Response to Submissions Report

State Significant Development – SSD 9483

Chatswood Public School and Chatswood High School

5 & 24 Centennial Avenue, Chatswood

1 INTERFACE OF BUILDING P1 AND PRIVATE PROPERTY - SECTION AA  
SCALE 1:100

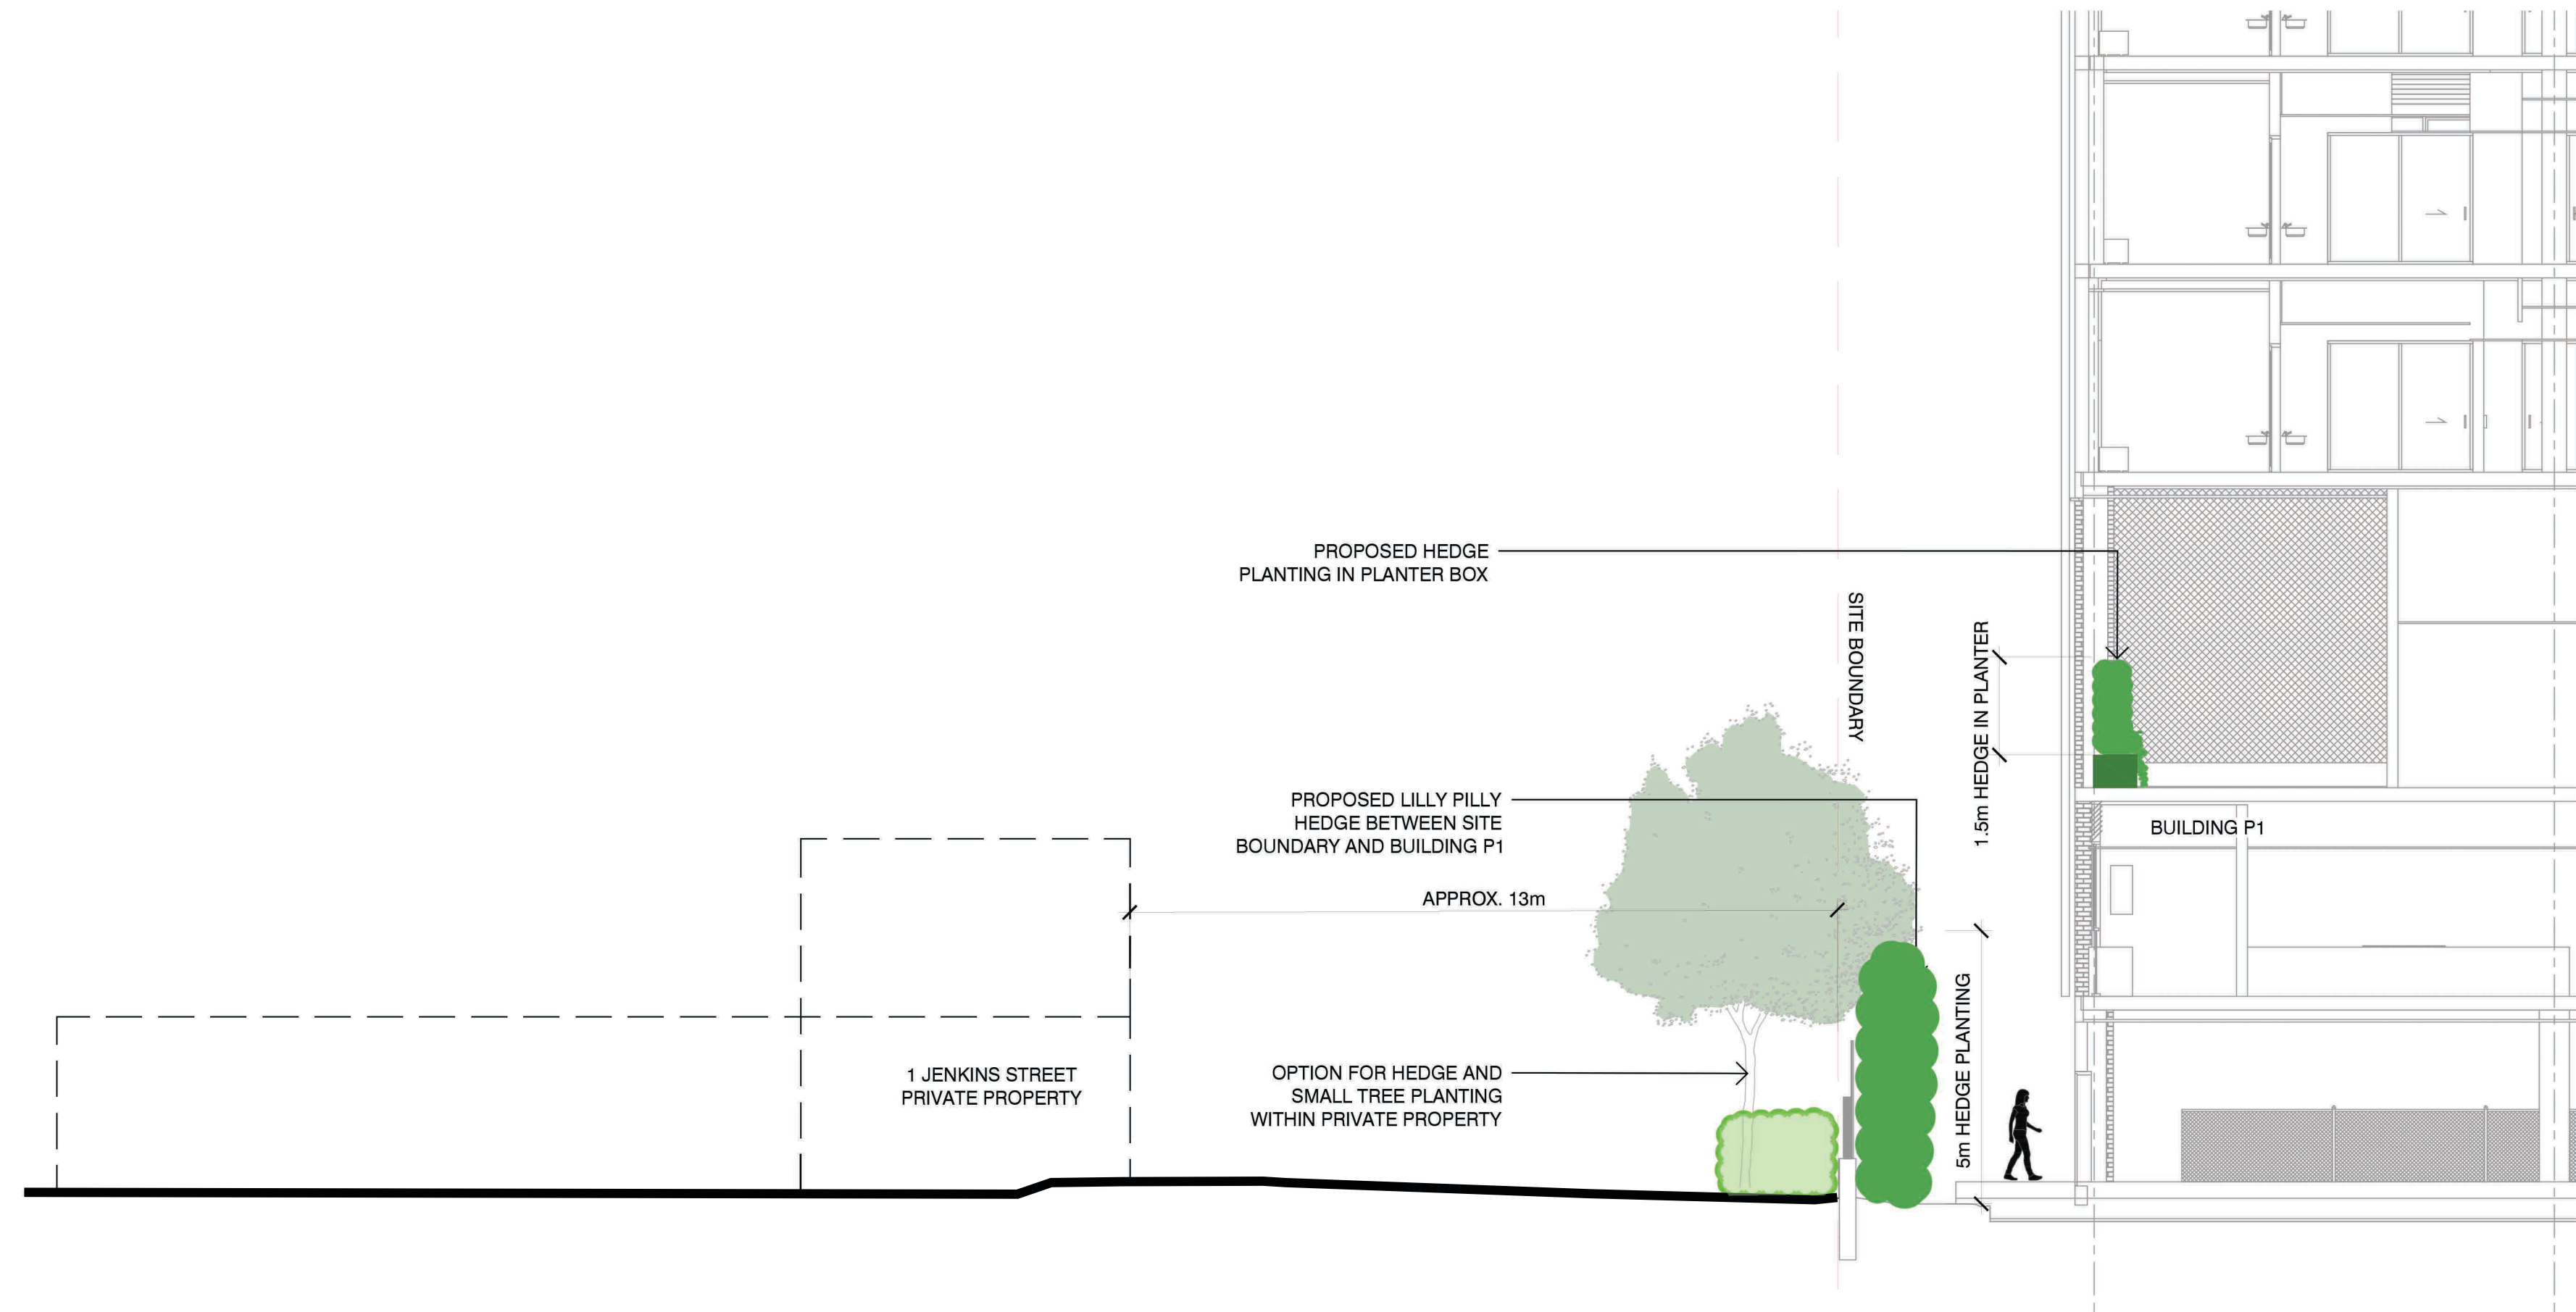
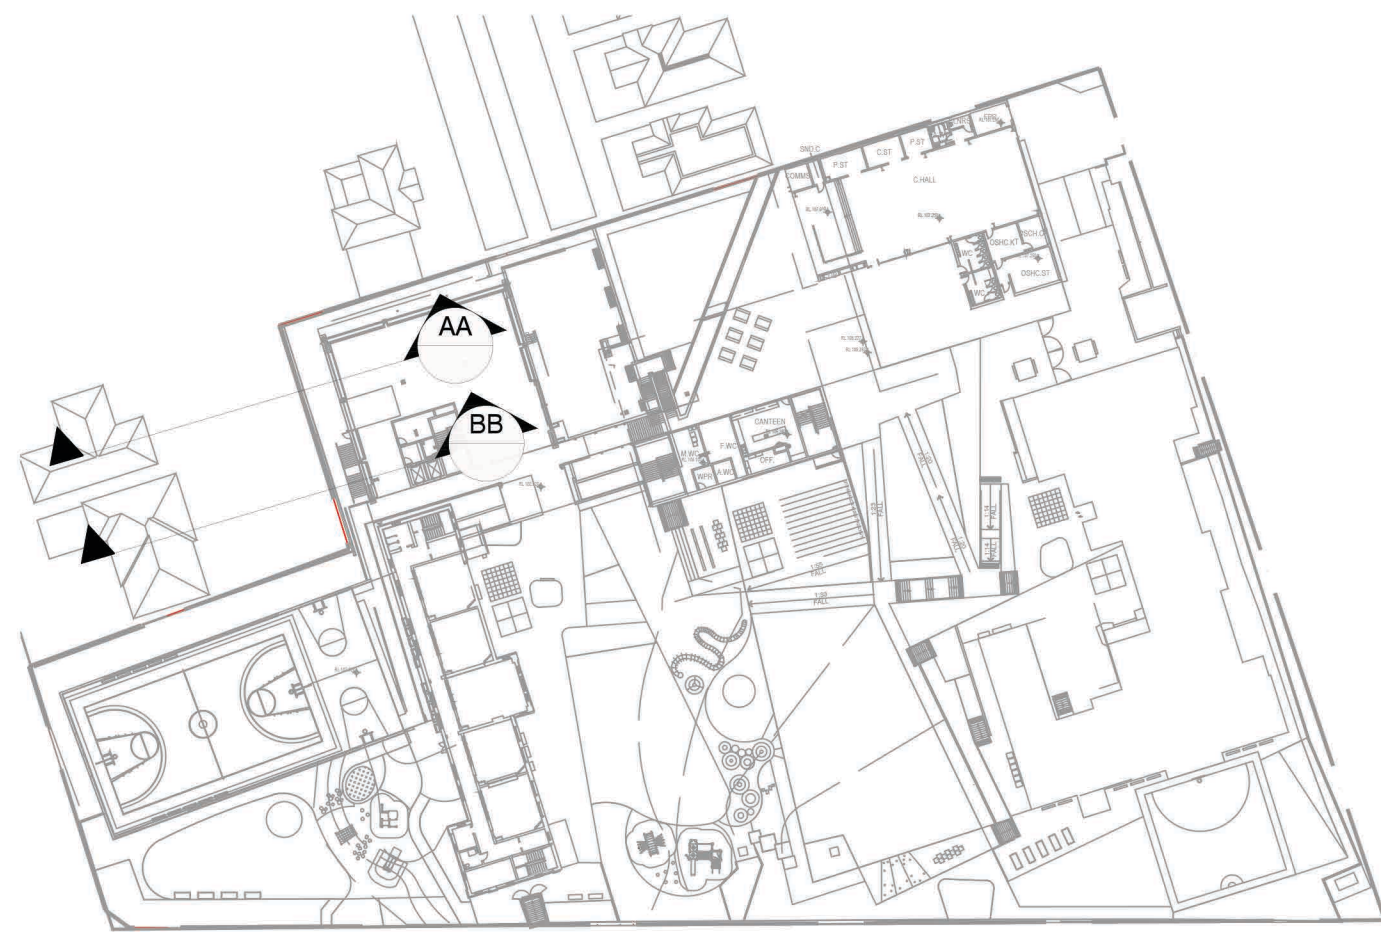
Issue	Response	Reference
Building P1 – Chatswood Public School site Multiple public submissions raised concerns about height, bulk and scale impacts of P1 and related issues including: • Privacy concerns for residents in James Street and Jenkins Street; • View loss; • P1 located too close to residential boundaries; • Bulk of P1 should be pushed up to Pacific Highway where taller buildings are the norm; • Concern about projectiles being thrown from open play space into resident's yards • Concern about impact to streetscape	Detailed assessment in relation to Building P1 has been provided in the cover letter and in the Architectural response to submission. The location of the new buildings on the Pacific Highway and along the northern boundary: a) creates better connection, accessibility and use of the Lowers, which is currently an under-utilised outdoor space as it is difficult to access; b) takes advantage of the level changes of the Lowers and enables new built form to maximise scale without overpowering the existing heritage buildings; c) location of new buildings on the northern part of the site maintains the scale and key heritage views along the streetscapes of Centennial Avenue and Pacific Highway; d) allows appropriate space around and between the heritage buildings; e) allow an increase in valuable outdoor space. The new buildings have minimal shadowing impacts of neighbouring properties to the north and west - marginal in comparison to the shadowing causing by development within the Chatswood CBD. The design of façade and glazing elements support views out from the building, rather than down, to maintain privacy to neighbours. There is minimal glazing to the west for sustainability purposes. Maximising outdoor space has been a key driver for the project. The height of P1 is largely due to the provision of an under cover outdoor space at Level 1. The new Buildings P1 & P2 not only create new opportunities for outdoor spaces, but allow better connections to existing outdoor spaces. The building height along the boundary streetscapes is consistent with the scale of the neighbouring buildings adjacent to the site. The taller buildings have been consciously located away from the street frontage. A more detailed response is provided in the Cover Letter, including discussion of alternative design options and additional design treatments to Building P1.	See Cover Letter Attachment 2 Attachment 8 Attachment 9
